Subject: RE: P/111/21/RES - Sefter Road - Planning progress

However, having looked again at the application/my previous notes, it is my intention to refuse the application on the basis of overdevelopment and harm to character.

Project
Land adjacent to Seftor School House
Seftor Road
Bignor Regis
PO21 3EE
Drawing Title
Plots 2 and 3
Floor Plans and Section

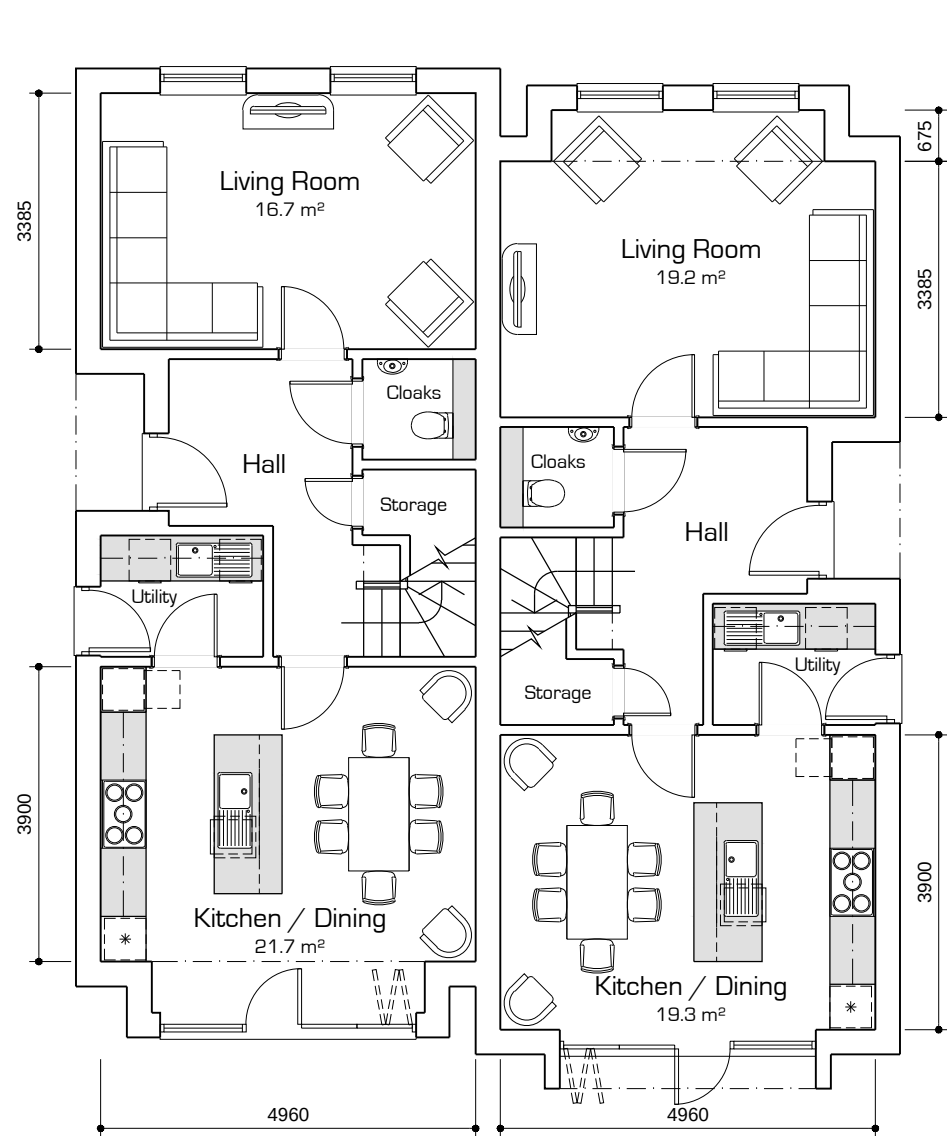
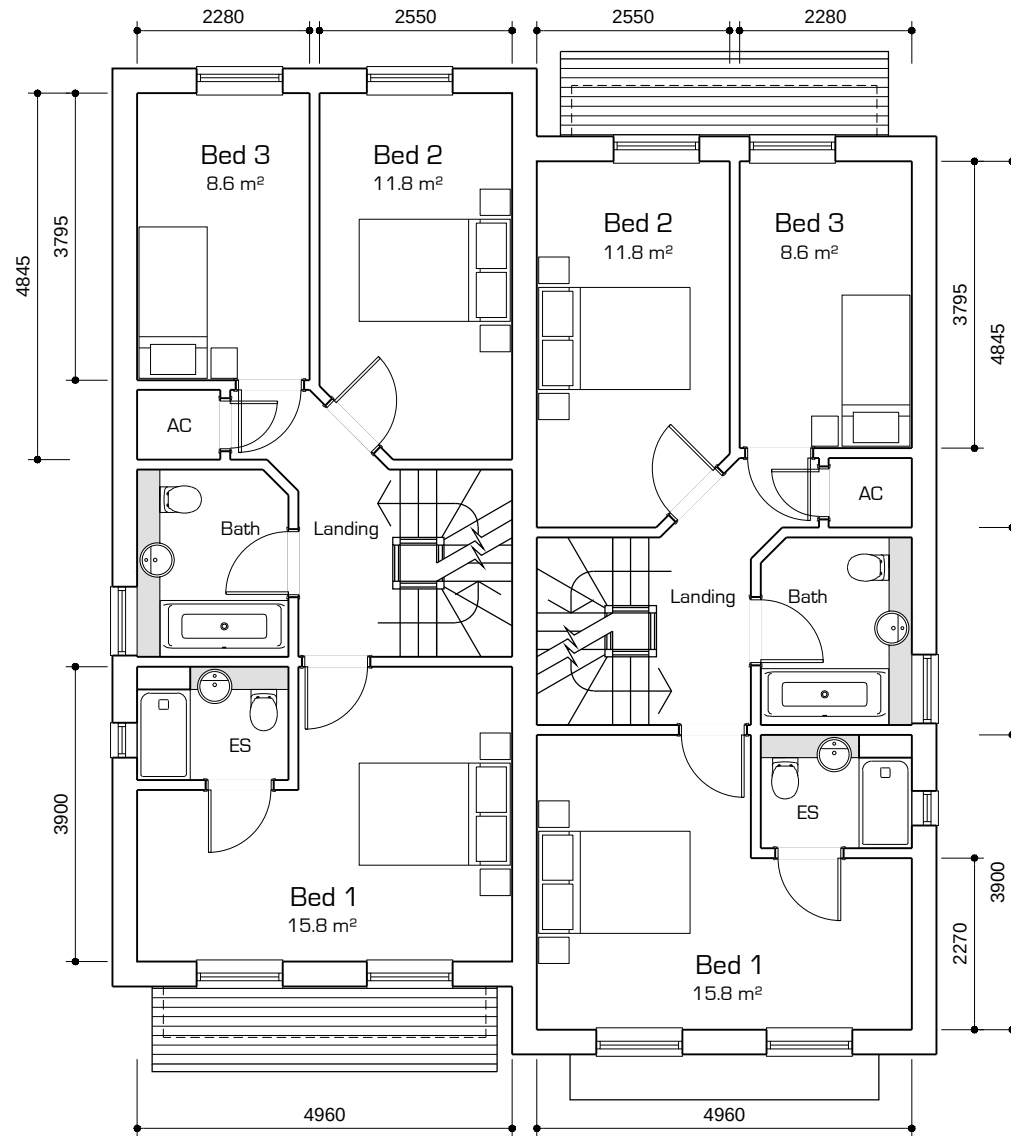
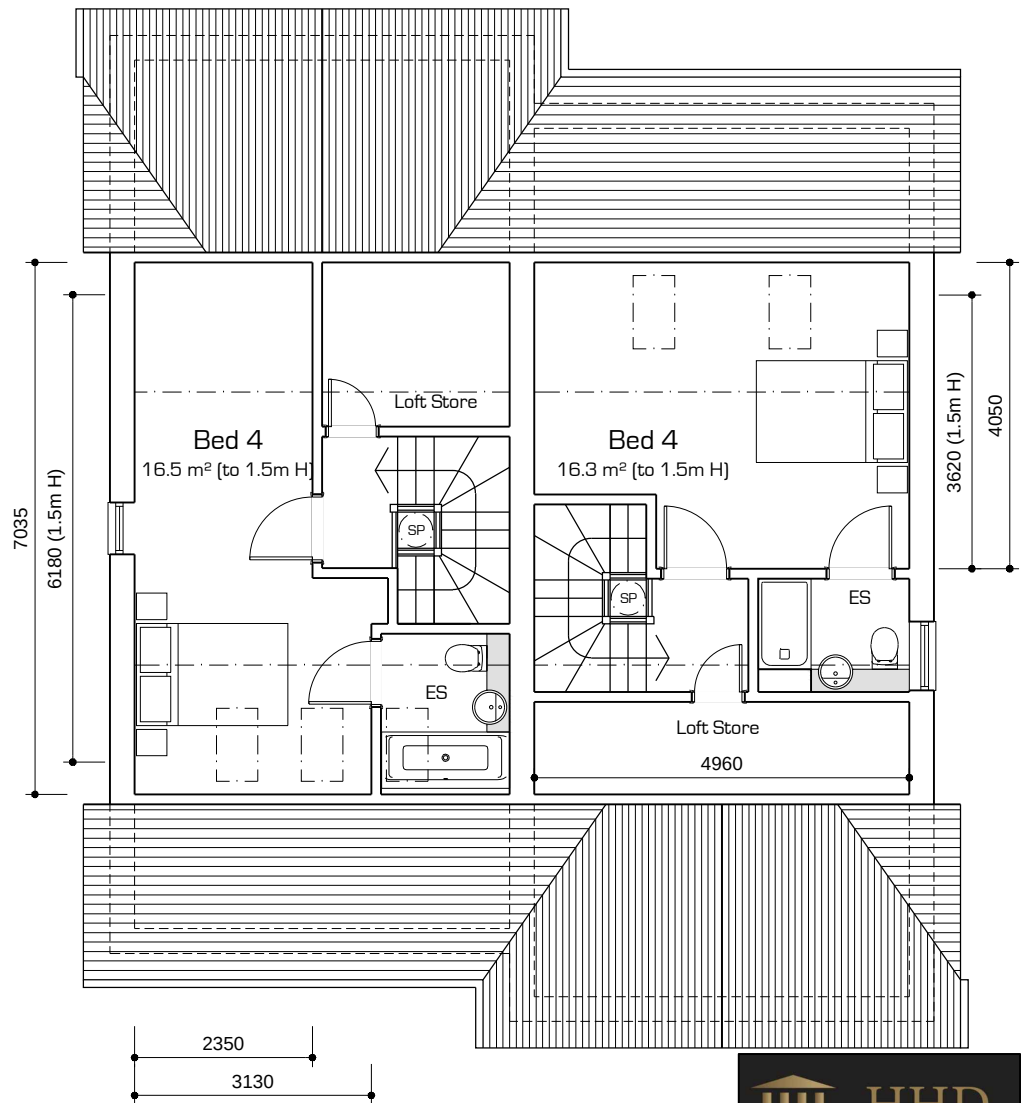
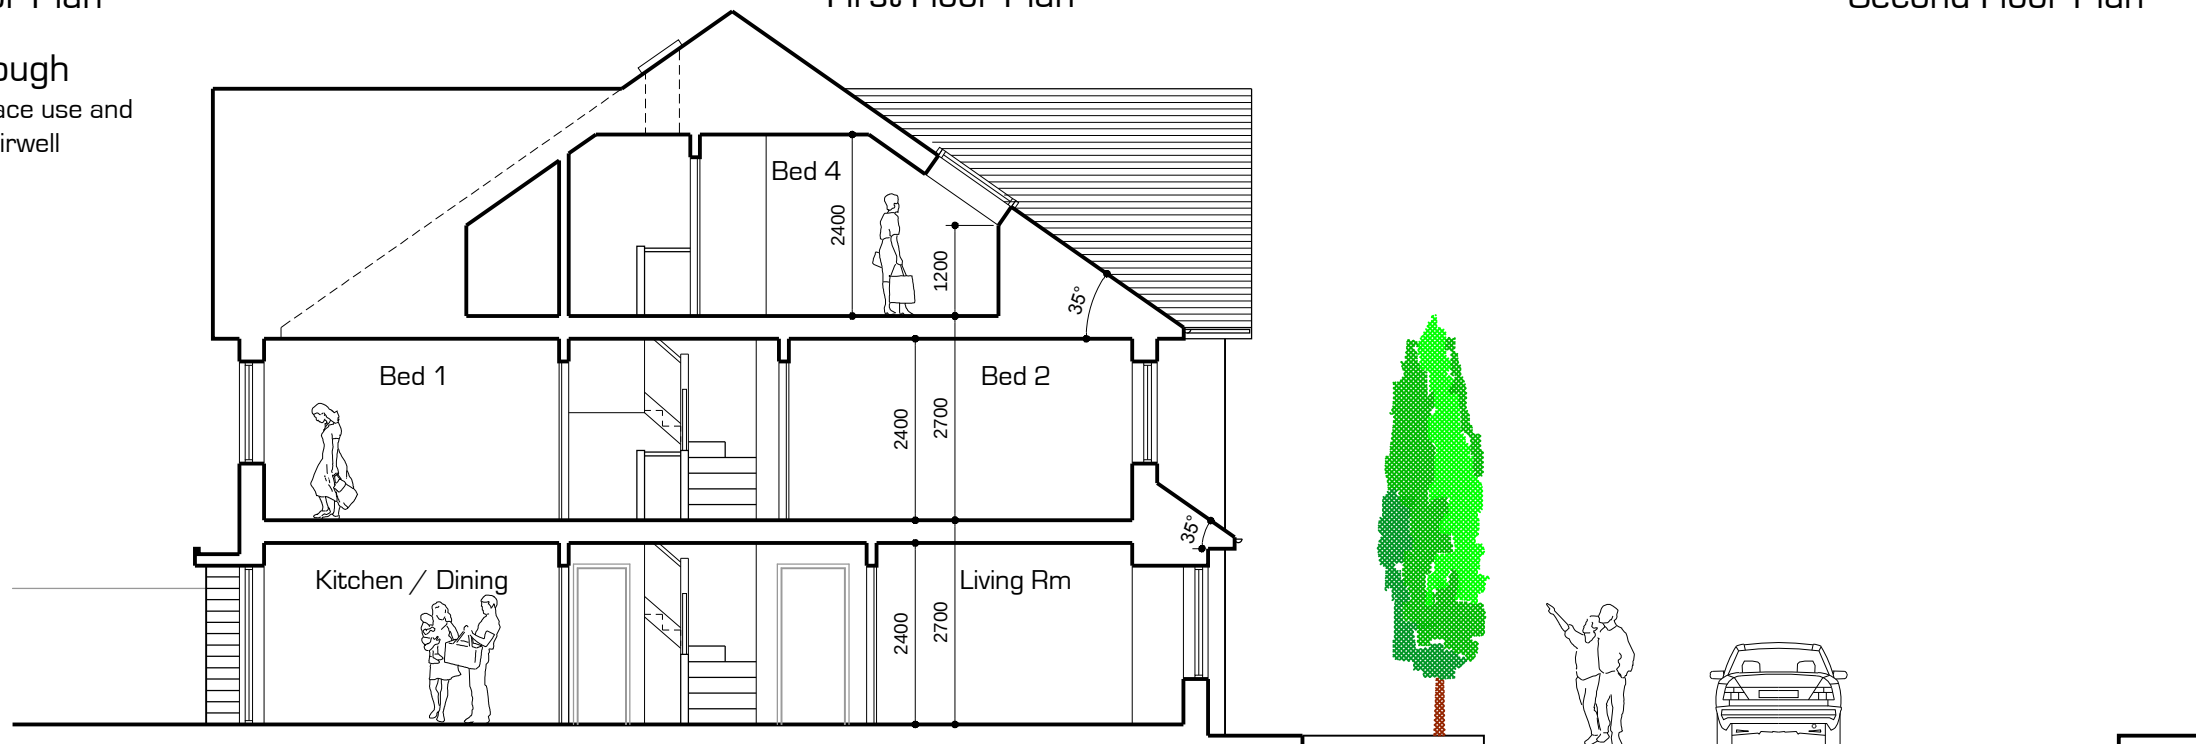
I acknowledge that we have given outline consent for 4 semi-detached 3-bedroom houses and 2 detached 4-bedroom houses and so we have to allow this number of houses and mix/no of beds. However, I have concerns with the closeness of the houses to each other, their size (floor areas are well in excess of minimum space standards), the height (inc roof level accommodation) and materials (weatherboarding not considered appropriate to the local context). Also not all gardens (plots 1 & 2) meet the 10.5m depth requirement as per the Arun Design Guide and garden depths across the layout appear to extend beyond/into the fenced easement to the stream.

I acknowledge the proposed residential development on the strategic allocation next door however the submitted RM for that site (P/79/21/RES) has a large SUDS area and POS adjacent to the boundary with houses at least 100m away thus minimising the impact on this urban extension on the rural character of the area. I therefore do not consider that this sets any form of precedent for an urban form of development on the plot. In addition, house types on the RM (WE, AR, GO, SR) that are closest to your site are all proposed as straight two storeys (no roof accommodation).
